From:
Sent: 09 January 2026 16:31
To: DC Admin
Cc: Edward Cheseldine
Subject: Planning Applications 2025/93234 and 2025/93235

Response to Planning Applications 2025/93234 and 2025/93235

Drawing Title General Arrangement and Detail Drawing

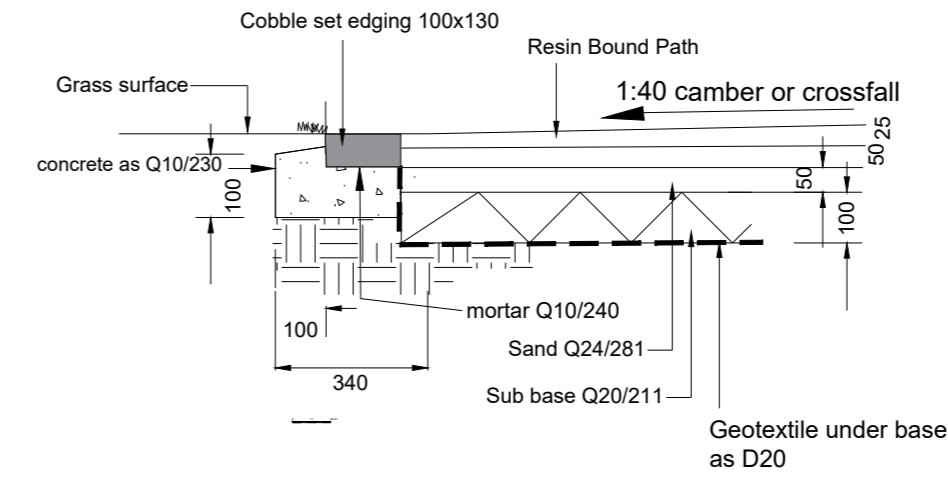
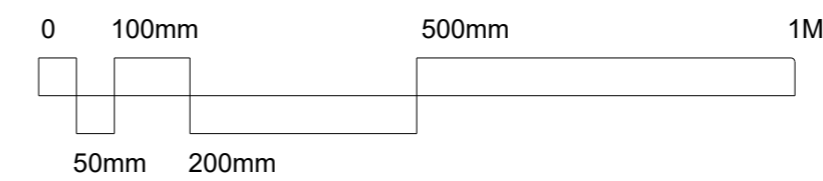
The proposed siting on the plans means that it will not be visible along Wyke Lane and only to those on Cross St which reduces significantly its important heritage position.

IF the Cross is to be relocated, HE favours the nearest position which would be the site of the cherry tree on the grassed area, and this would maintain the visual perspective of its significance. This is

also a flatter area for construction. Surely this is better from a heritage perspective as long as one or two trees are planted further down Cross St as replacements.
